December 6, 2017

Mountain View Electric Association, Inc. (MVEA) has these comments about the following:

Project Name: Pioneer Landing at Lorson Ranch, Filing #3

Project Number: SF-17-022

PIONEER LANDING AT LORSON  
RANCH FILING NO. 3  
JOB NO. 70-024  
DATE PREPARED AUGUST, 2017  
DATE REVISED: DECEMBER, 2017

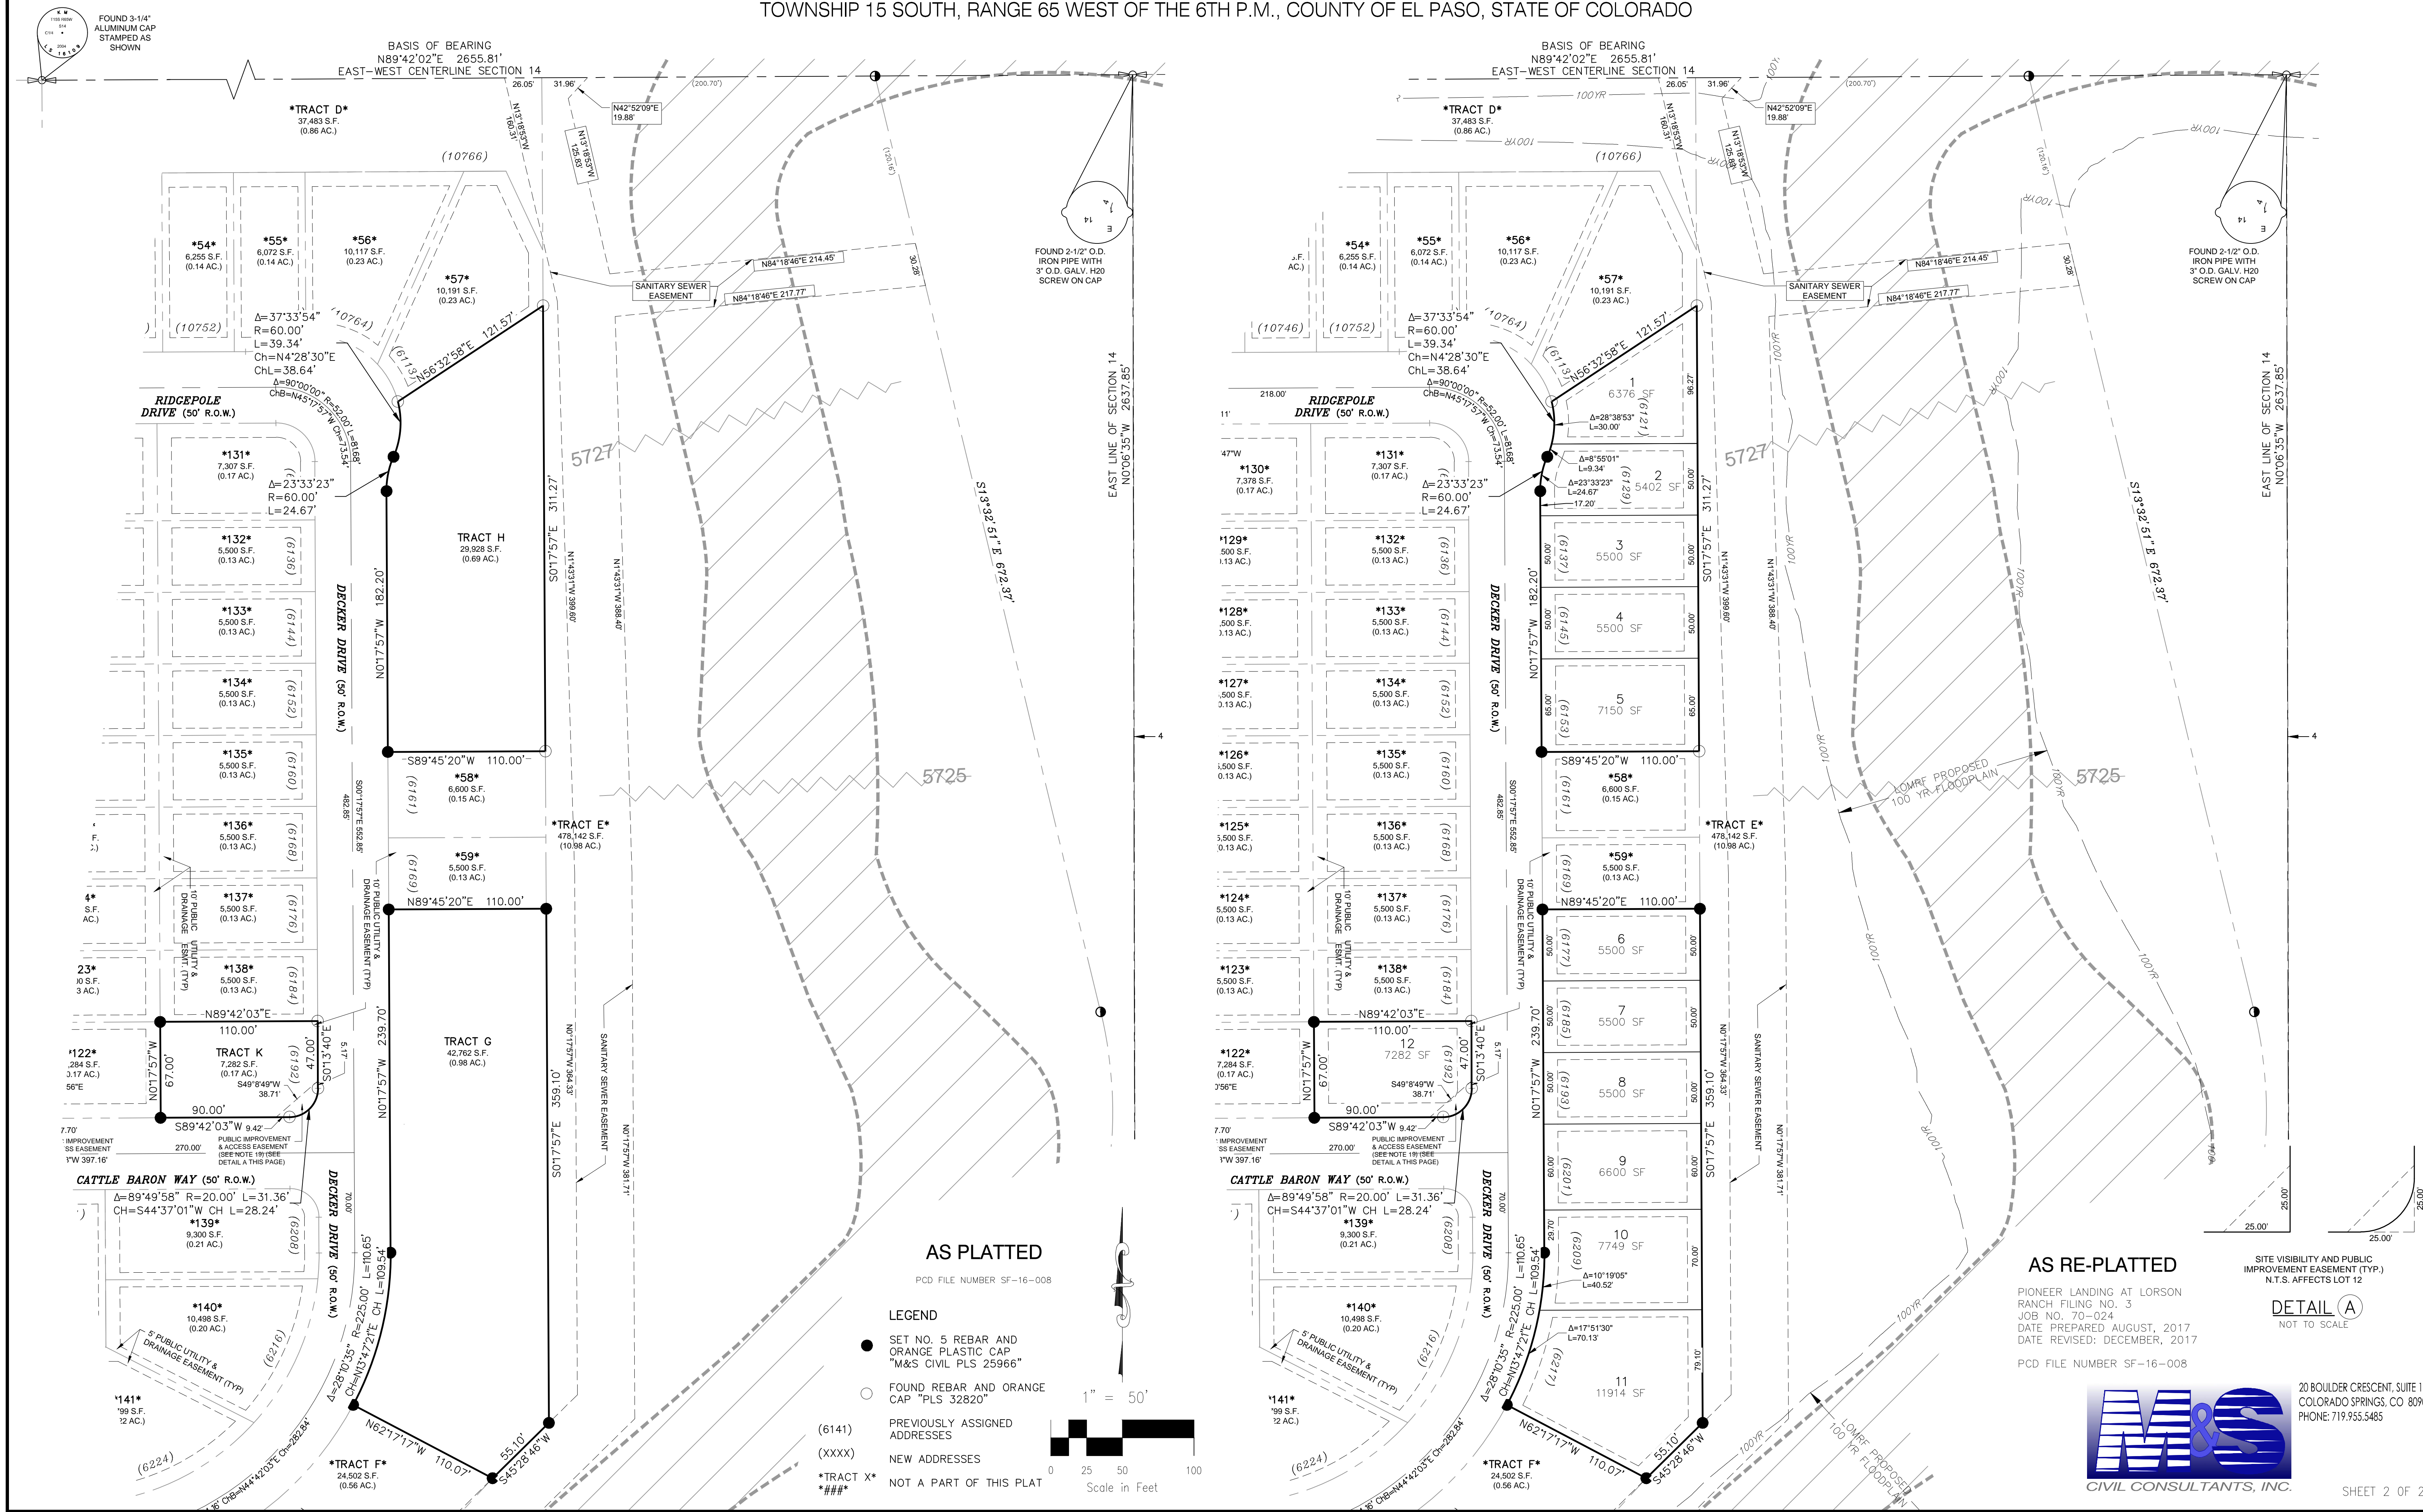
MVEA requests a ten (10) foot front and rear lot utility easement, five (5) foot side lot utility easement to coincide with previous filings of Pioneer Landing. MVEA also requests platting of existing MVEA facilities with easement on the plat. Additional easements may be required once a review of civil drawings with grading and erosion plan is provided to MVEA in order to serve this filing.

MVEA has existing facilities near and within this filing of Pioneer Landing. If there is any removal or relocation of facilities it will be at the expense of the applicant and a review of easements will be required in order to serve.
